From: Laura Gibbons
Sent: 13 September 2018 15:32
To: Planning.Responses
Cc: Zac Denton
Subject: RE: Planning Consultation on: M/109/18/HH

Engineers Comments Regarding Surface Water Drainage

APPLICATION M/109/18/HH

Description of Works: Replacement detached garage.

PROPOSED GROUND FLOOR PLAN

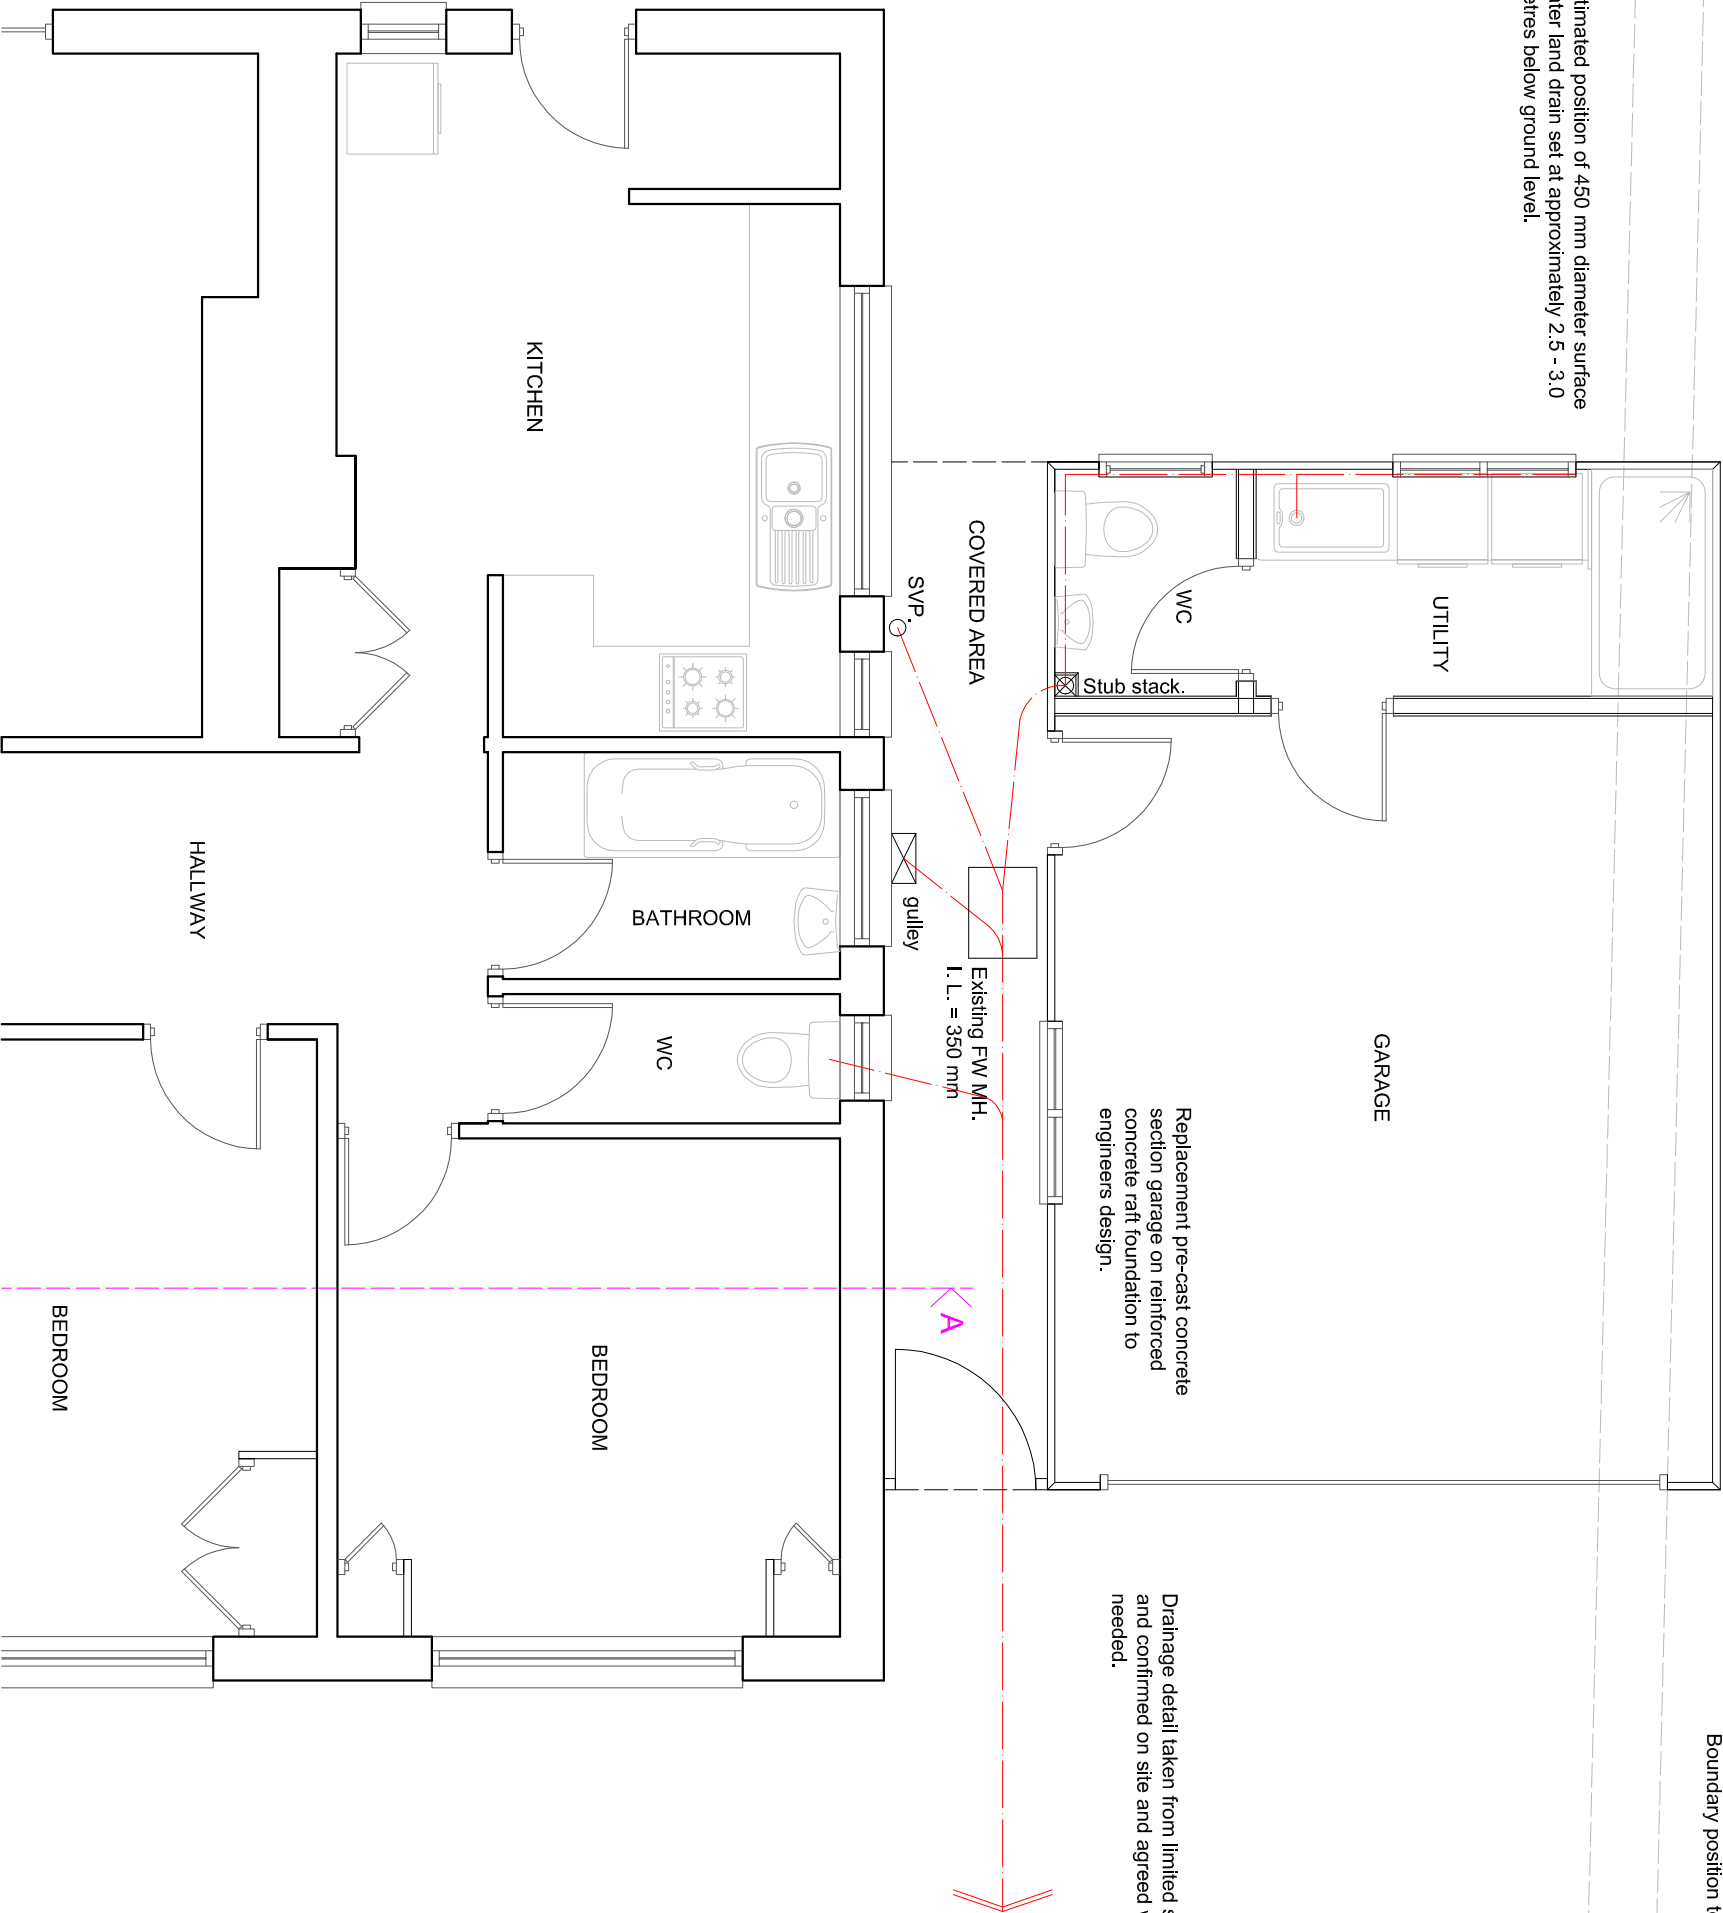
There is a 300mm diameter culverted ordinary watercourse running under the existing garage and the proposed structure.

Our byelaws state that no development should occur over or within 3m of an open or culverted ordinary watercourse. However, as the application is for a replacement structure agreement will hopefully be made in this instance. In order for the development to be permitted the developer must demonstrate that the replacement structure will not place any load onto the culvert and that maintenance will be able to be carried out by the riparian owner.
